**Consultation Response from KC,
Trees****2025/91786 Brookside, 67, Hall Ing Lane, Honley, Holmfirth, HD9 6QW****Erection of extensions and alterations****Date Responded: 08/07/2025****Responding Officer: JD****Responding Ref: 01/96**

Proposed Site Plan - 1:500

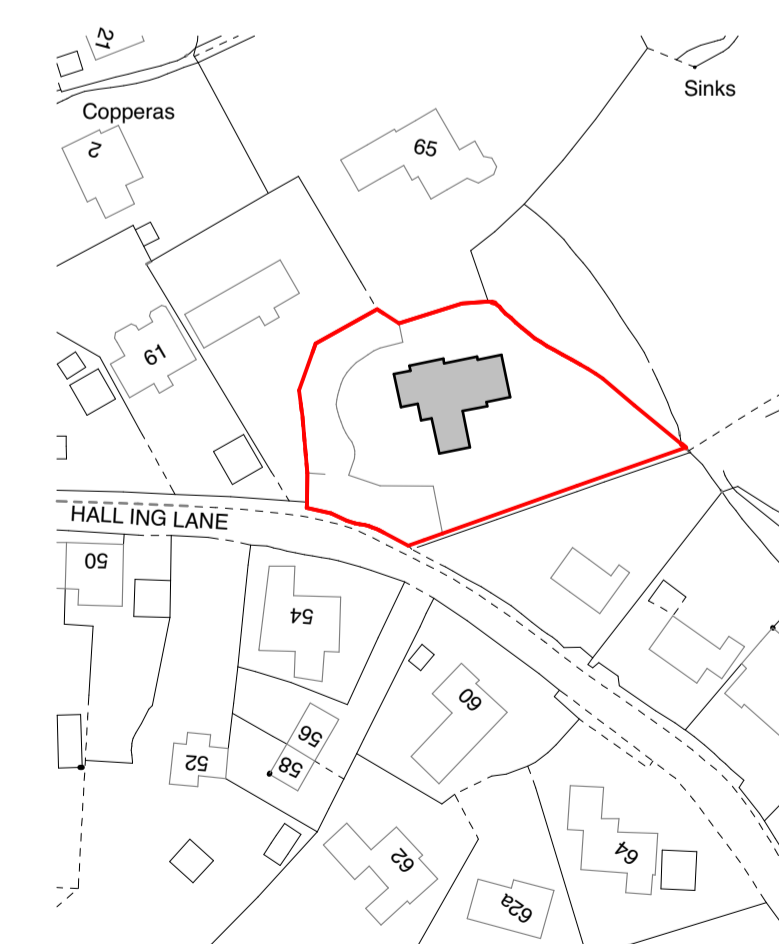
None of the TPO'd trees will be impacted upon from any of the proposed work.

There is minor infringement into the RPA of T004. This is not a protected tree and the proposed new paving within the RPA is so minimal there will be little to no impact on the trees future viability.

The proposals look largely achievable with no impact on the retained trees and the tree protection fencing is adequate to prevent any damage to the trees during construction.
